From: Colin Chandler [REDACTED]
Sent: 07 November 2018 18:11
To: Planning.Responses
[REDACTED] Karl Roberts; Cllr. Paul Bicknell; Cllr. Andy Cooper; Cllr. Dudley Wensley
Subject: 53 Mill Road Avenue

Dear Mr Denton
Re: 53 Mill Road Avenue, BN16 4HX
Applications: A/128/18/CLE and A/132/18/HH

PROPOSED ELEVATIONS 1:100

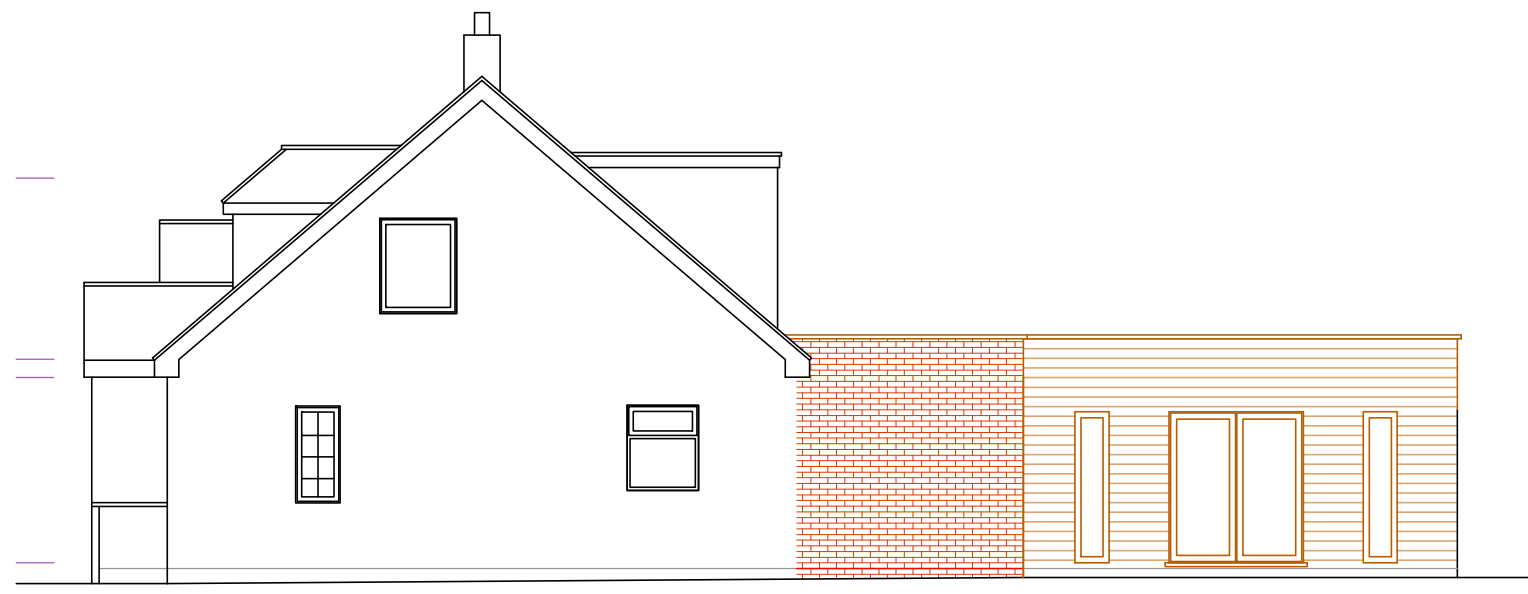
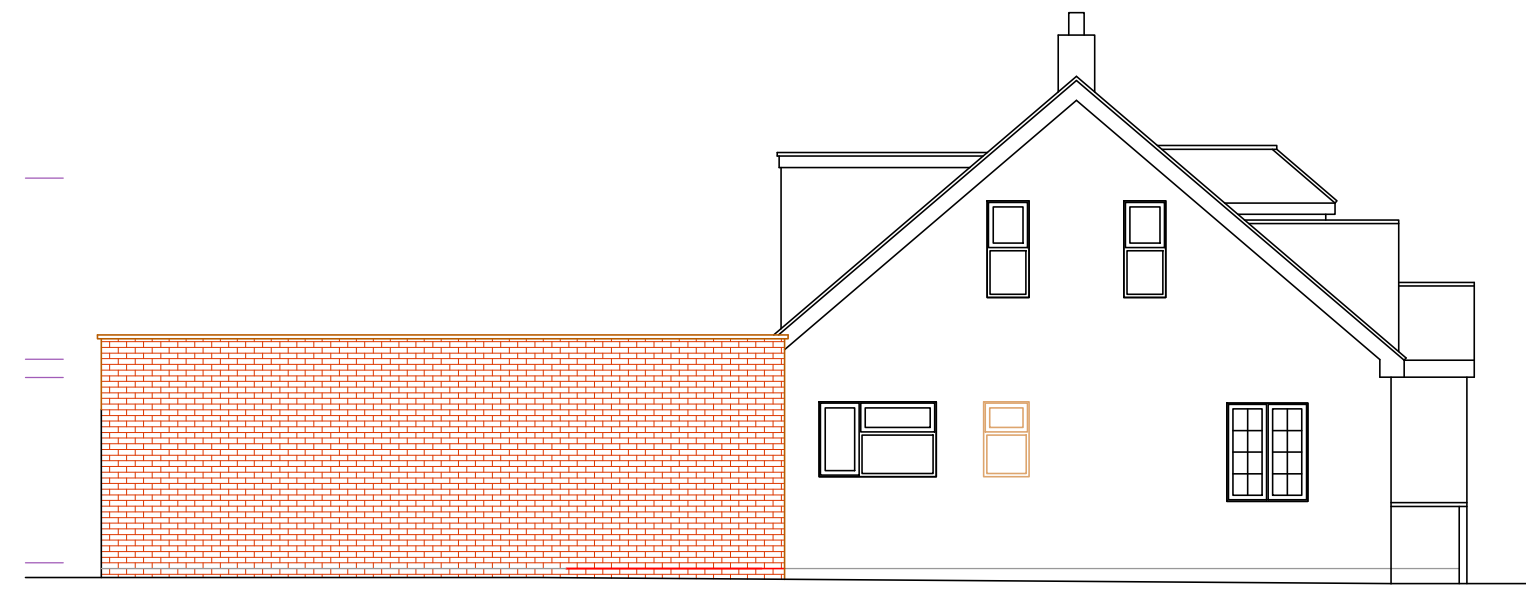
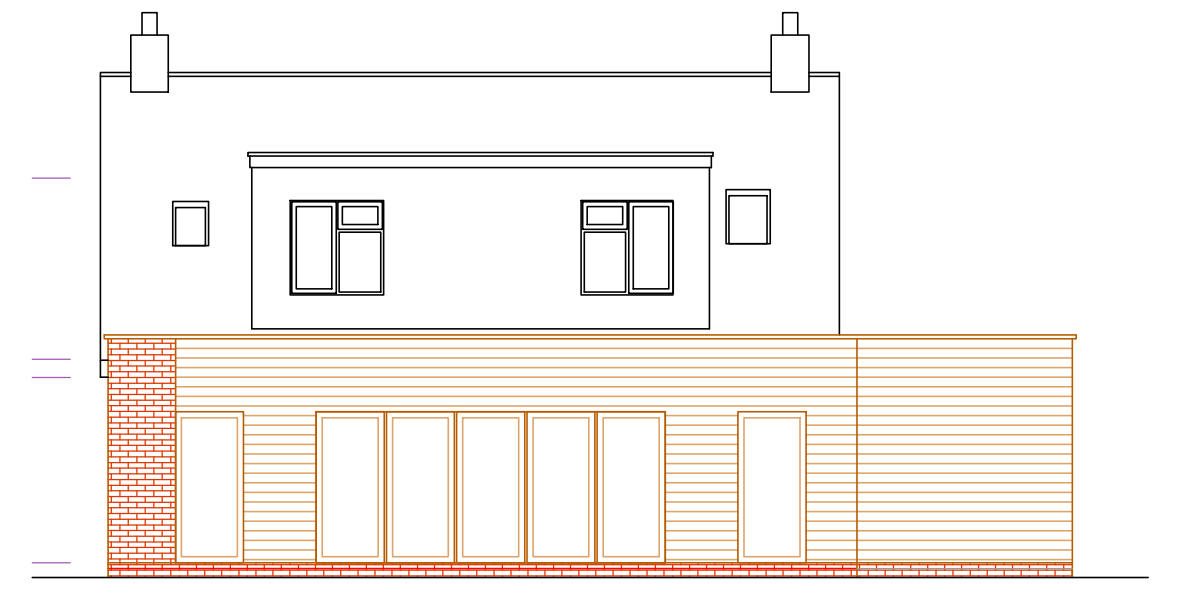
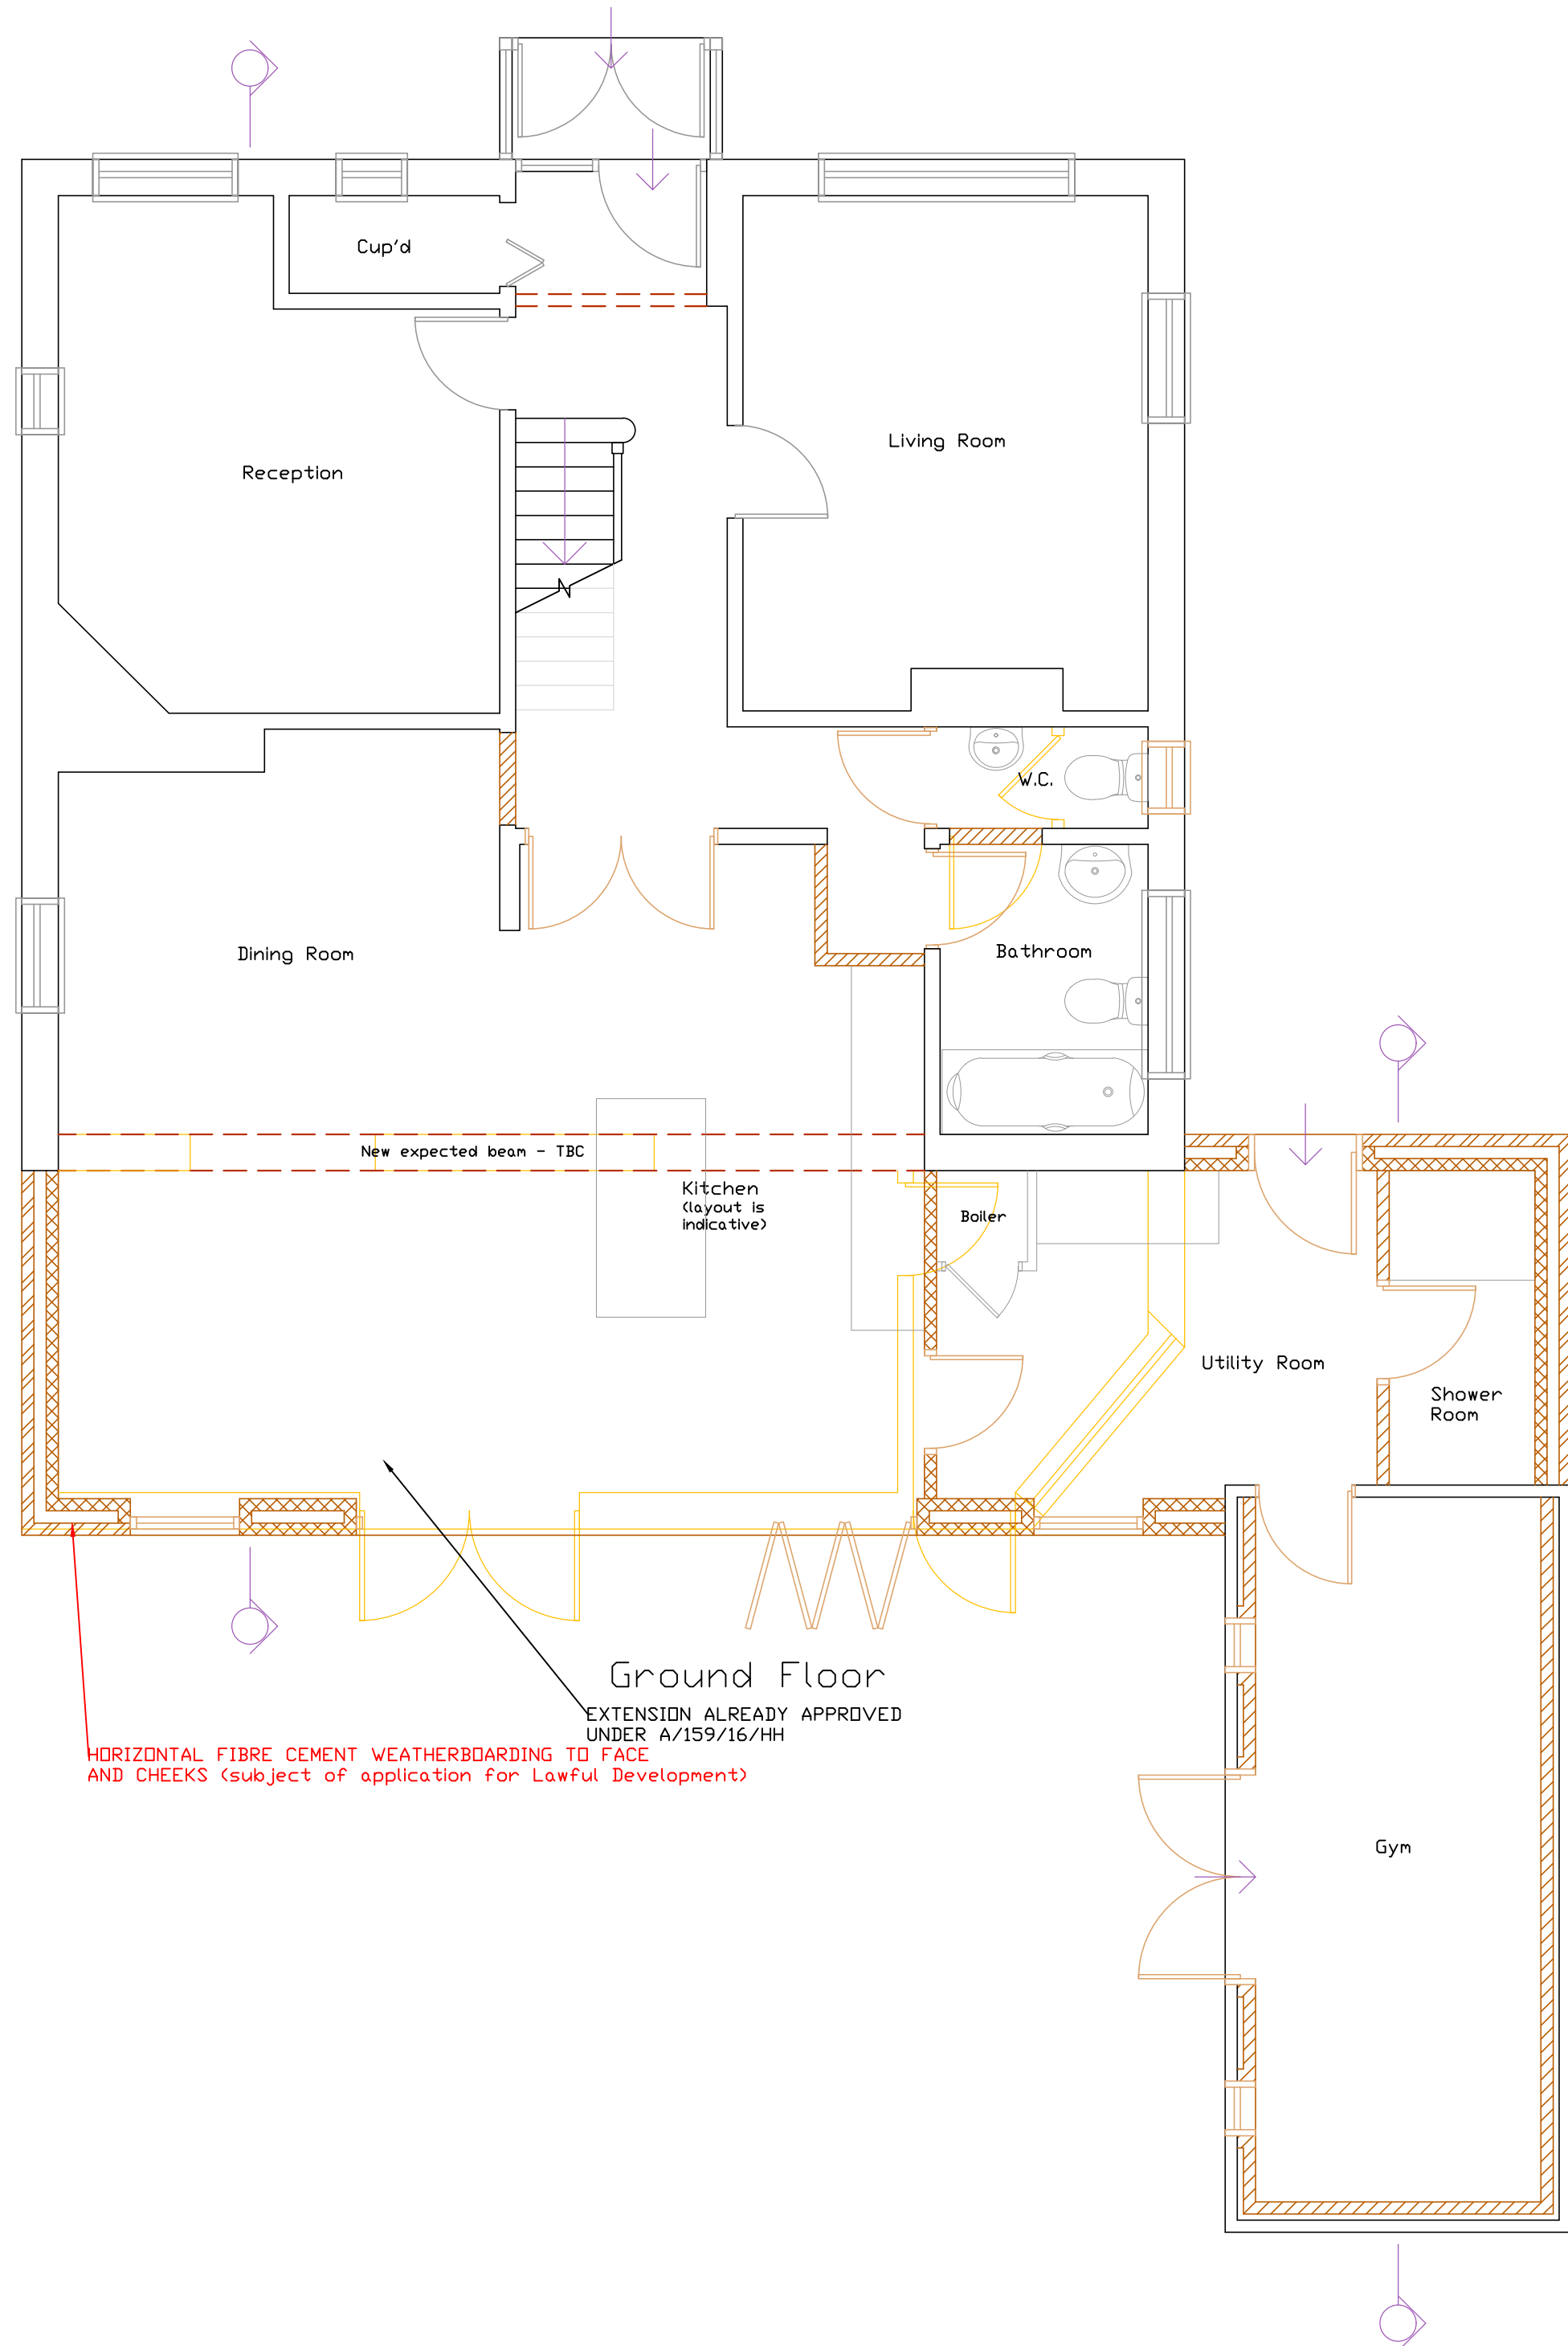
The Parish Council (PC) on 30/10 resolved to raise no objections to the current 3 applications at the above site. Regrettably, we could not attend that meeting but from neighbour feedback we remain concerned that material considerations were not taken on board. Our primary concern is the proposed use of horizontal cladding (mock timber) on the recently extended dormer.

We see that since making our previous representations and the PC's consideration, two sets of French doors and two windows have now been installed and finished in grey - a colour that does not accord with other existing windows. That work also now appears to mean the test of lawfulness should fail, aside from the fact the openings bear little resemblance to that shown on the submitted drawing.

To be consistent and noting the particular restrictions on roof level changes, we believe that application A/132/18/HH for planning permission, (no doubt submitted in anticipation of A/128/18/CLE being refused) to clad the newly extended dormer at No.53 with similar cladding to that which was previously rejected should also be refused. The impact on the character and appearance of the surrounding area, as well as the No.53 itself, is demonstrated in the photo taken from our own similar dormer. (No.53, is on the left, showing their dormer before recent additions.) This application remains incomplete without a proposed rear elevation of the dormer.

As previously stated, there is a perfectly acceptable alternative to 'dress' the dormer with traditional tile hanging, subject to suitable *similar* colour choice.
